Subject: FW: 23420 - RE: Planning Consultation on: F/17/20/DOC

Engineers Comments Regarding Surface Water Drainage

Application No: F/17/20/DOC
Registered: 3rd August 2020
Site Address: South Yard B Wicks Farm Ford Lane Ford BN18 ODF
Description of Works: Approval of details reserved by condition imposed under ref F/5/19/PL relating to Condition No 5 - surface water drainage

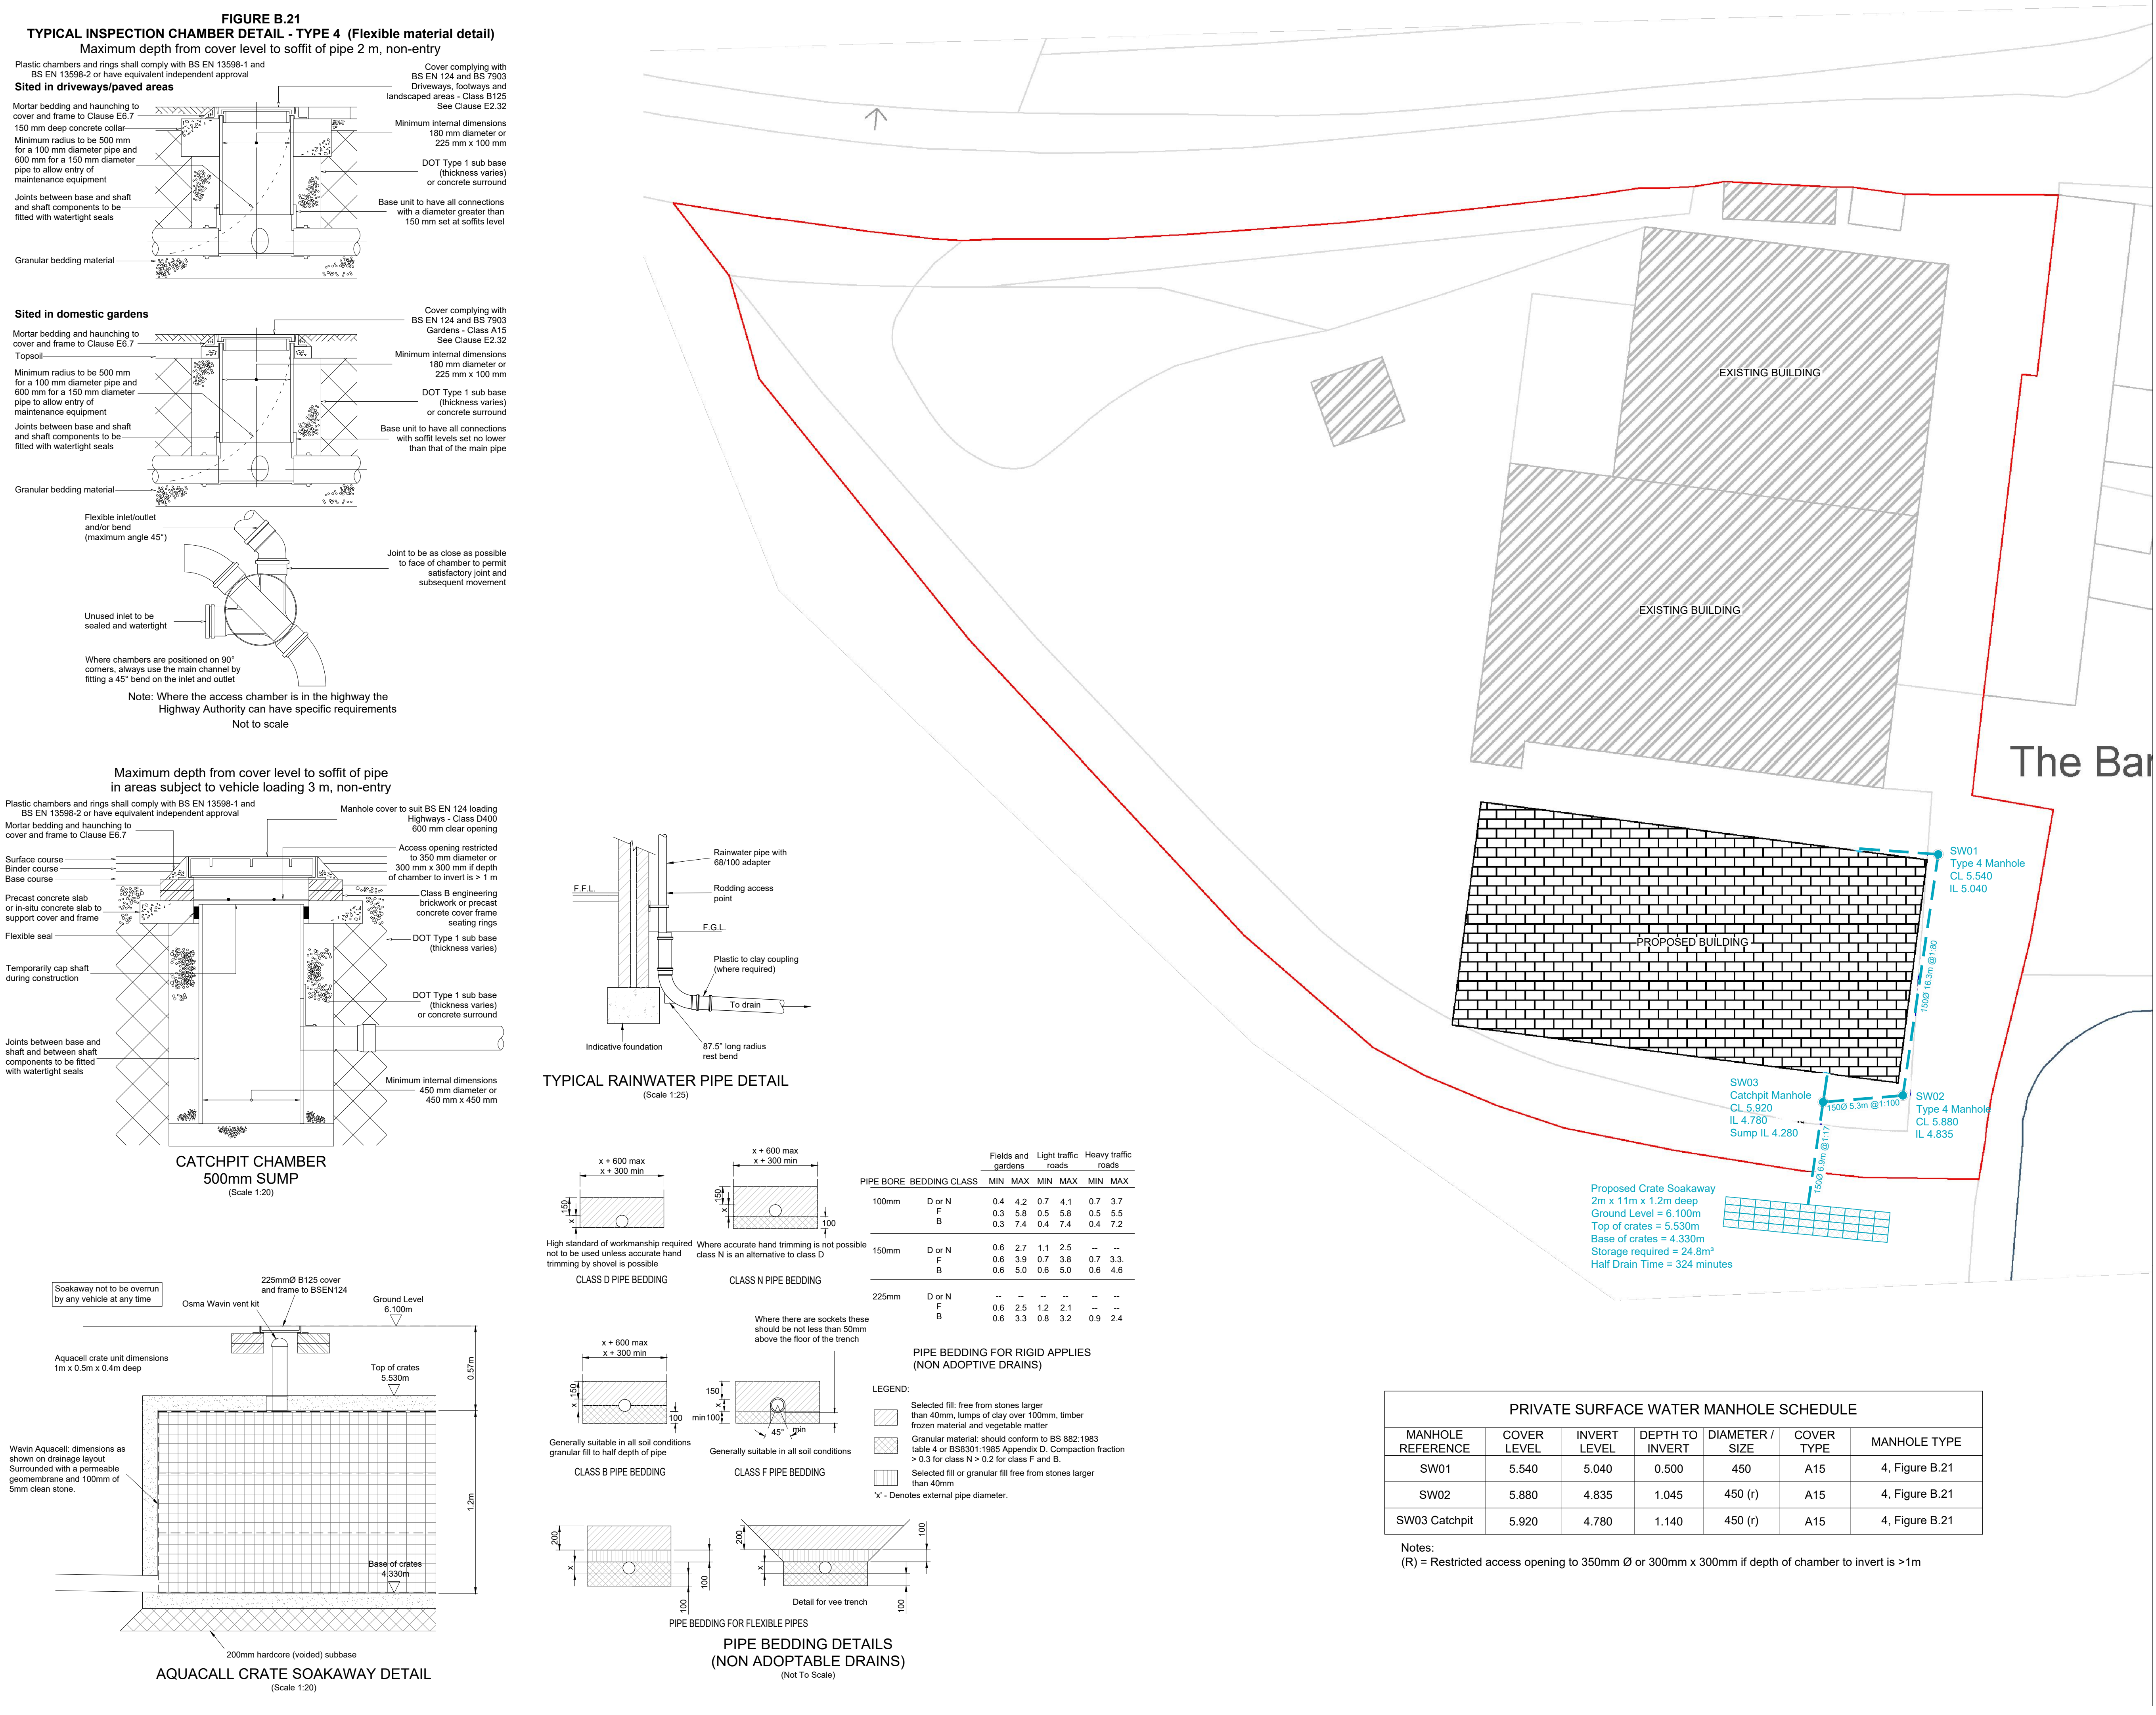
The incoming pipe to the soakaway is set at the base. Our requirements state that the 1 in 10 year storm must be catered for between the invert of the lowest entry pipe and the base of the infiltration structure. Please re set this pipe as high as possible and adjust both the invert level on the layout and the construction detail to reflect this.

I am concerned that the soakaway is shown to be in a location outside of the applicant's ownership (red line). Does the applicant have approval to be siting a soakaway outside of this site? I have checked the original application and there was no extended part of the site shown as the same ownership (blue line). If possible we would like to see the surface water drainage contained within the red line boundary for the site.

I attach the updated drainage plan indicating the new higher invert level for the incoming pipe to the soakaway.

The new invert level for the pipe is now 4.850m which is 520mm higher than the base of the soakaway providing more than enough volume beneath to accommodate for a 1 in 10 year storm.

The manhole schedule and construction detail have also been updated based on the above.
